Buildings Archaeology Team

5th September 2022

Lower Reaps Farm, Whinney Lane, Mellor, BB2 7EL. Application No. 3/2022/0727

Drawing Title  
Proposed Barn  
Floor Plans and Elevations

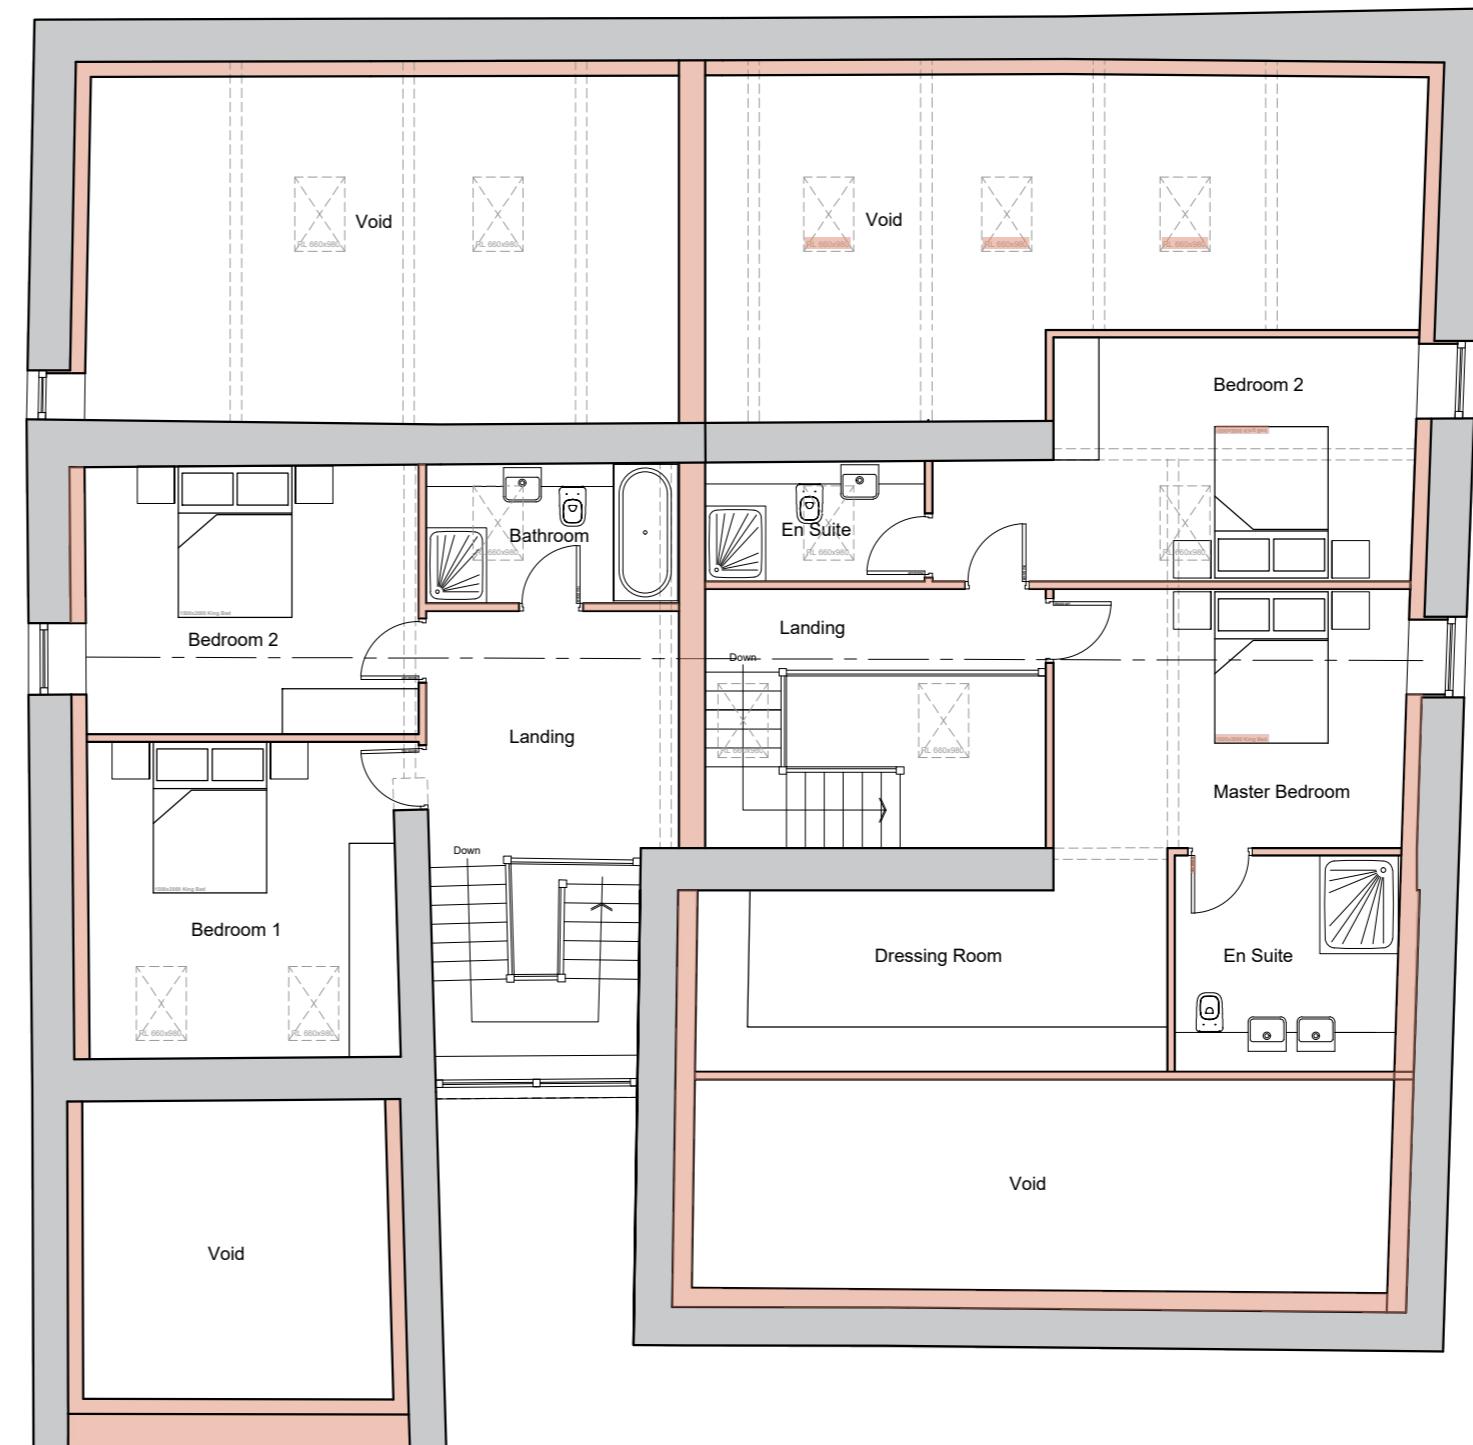
The CBA understand why the applicants view the principal barn as large enough to accommodate 2 domestic units. However, the way in which the proposed division cuts across the horizontal linear planform of the barn would prevent any appreciation of the relationship between the structure's form and agricultural function. Proposals also seek to demolish a lot of the original wall to this central core. A lot of new domestic openings are proposed in the west elevation and a lot of roof lights. This is an intensive scheme that would cause a high level of less than substantial harm to the building. At present these plans are contrary to the requirements of paragraphs 199 and 200 of the NPPF. The impact of the subdivision, internal demolition and creation of new windows does not afford sufficient 'great weight' to the conservation of the barn's significance. This level of harm to the barn's significance also lacks 'clear and convincing justification'. We recommend that revisions seek to reduce this harm to the barn's agricultural character, significance, historical value and legibility of its phased development.

A single domestic unit that retains as much of the extant building fabric as possible would be preferable for conserving the site's significance. If your LPA are satisfied that there is adequate justification for subdividing the barn, then the CBA recommend the horizontal linear plan form of the building should be retained as legible. Ideally an area where the full height and historic volumes of the barn can be appreciated should be retained. The barn may divide more successfully into unequal sized dwellings. Paragraph 202 of the NPPF is relevant here regarding balancing the level of harm to the building against securing its optimal viable use.
